Department Review Status Report

Project Name: BP-2020-30290

Cycle	Department	Reviewer	Email	Status	Reviewer Comments	Applicant
1						
2	Solid Waste	Darrell Laskowski	dlaskowski@cabq.gov	Approved	CO REQUIRED APPROVED DJ LASKOWSKI 09-02-2020 ALL INSPECTIONS FOR TRASH ENCLOSURE MUST BE DONE BY THE SOLID WASTE DEPARTMENT AND IS CONTINGENT FOR FINAL CO SIGN OFF	
	Fire	Laura Pavatt	lpavatt@cabq.gov	Approved	9/2/2020 CO AND INSPECTION REQUIRED	
	Transportation	Ernest Gomez	epgomez@cabq.gov	Corrections Needed	Disapproved • An approved TCL is required. Please contact Wooten Engineering for status update.	
	Building	David Wiley	dwiley@cabq.gov	Approved	Approved -- Sept. 1, 2020 BP2020-30290 Shell w/ Suite A & B -- CO: Certificate Of Completion -- Description: New Shell Construction -- Occ Class: N/A - - Occ Load: N/A -- Const Type: II - B \ Non Sprinklered - - Valuation: \$ 934,000 -- Square Ft: 4809 SQ. Ft. Total \ Suite A = 1839 Sq. Ft. \ Suite B = 2976 Sq. Ft. -- Scope of Work: Shell Construction --- BP2020-37049 Suite B - - CO: Yes -- Description: T - I -- Occ Class: B + U -- Occ Load: 47 -- Const Type: II - B \ Non Sprinklered -- Valuation: \$ See BP2020-30290 -- Square Ft: 2976 Sq.

Sheet No.  
**AS101**

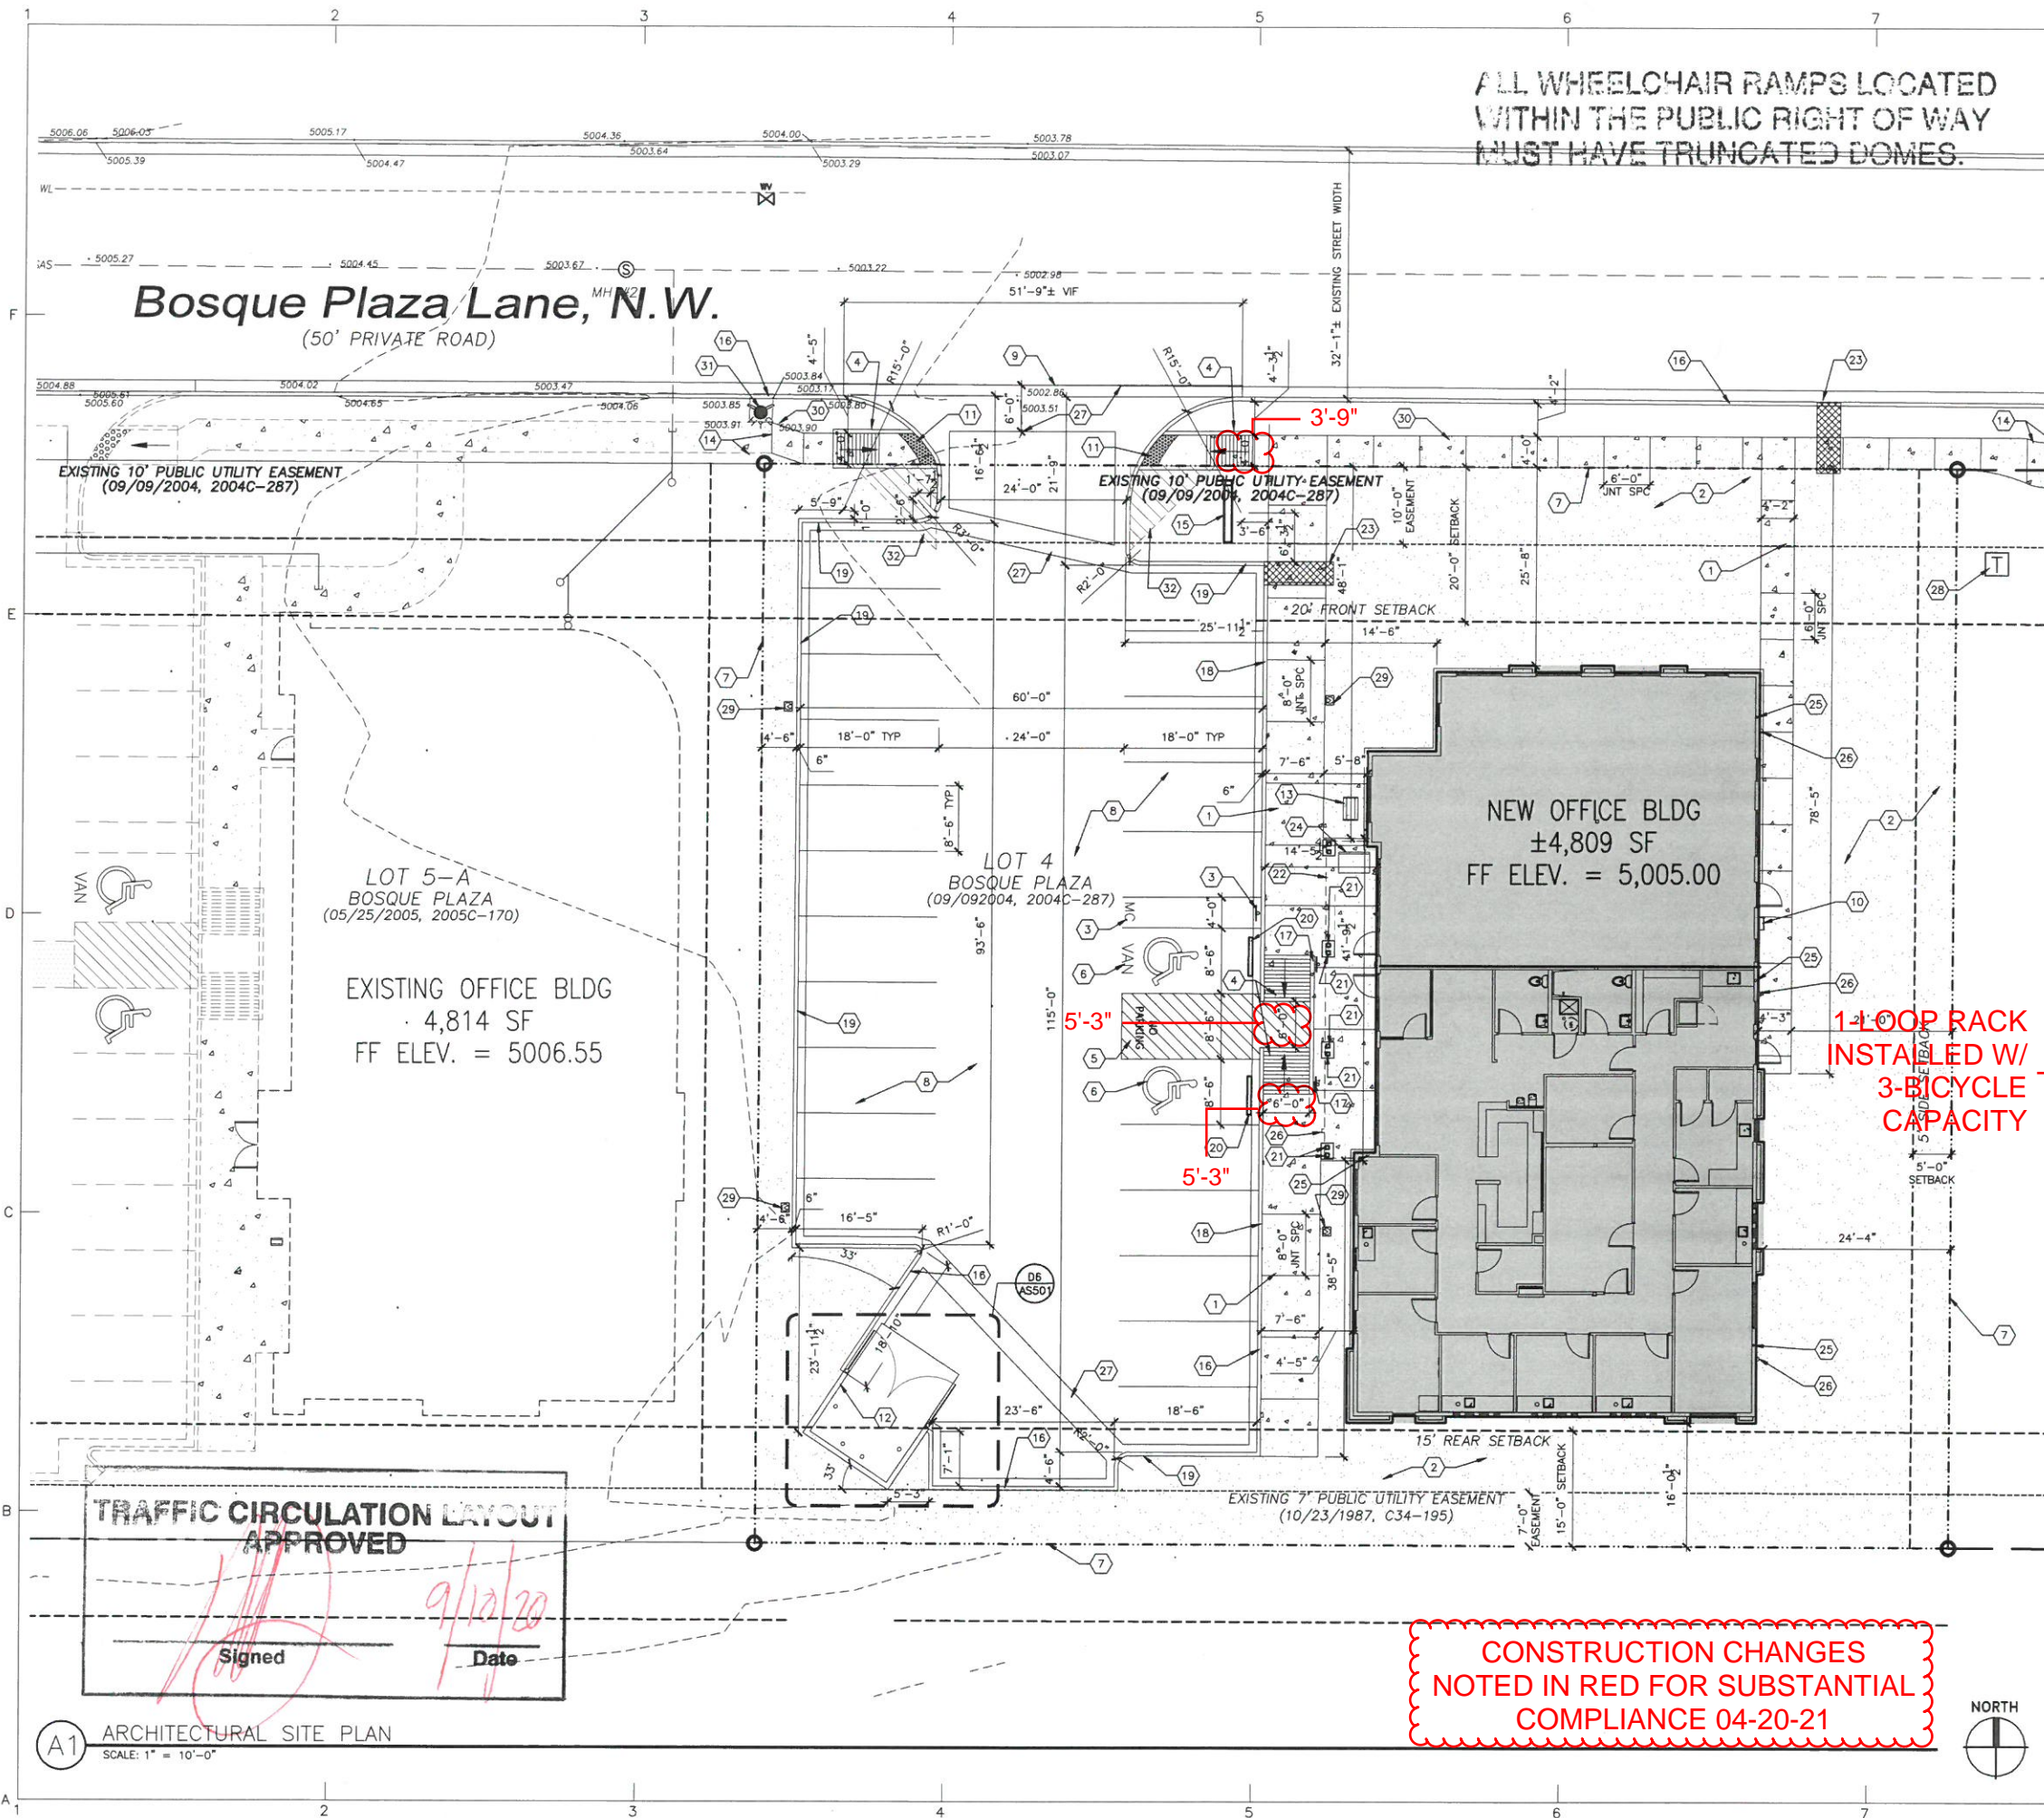
Electrical	Paul Ledoux	pledoux@cabq.gov	Approved	Inspections: Yes	
	Zoning	Charles Maestas	cdmaestas@cabq.gov	Corrections Needed	CO: yes Zoning disapproved 1. Upload documents indicating distance to transit stop and peak frequency allowing parking reduction. Charles Maestas 9/8/2020 924-3804
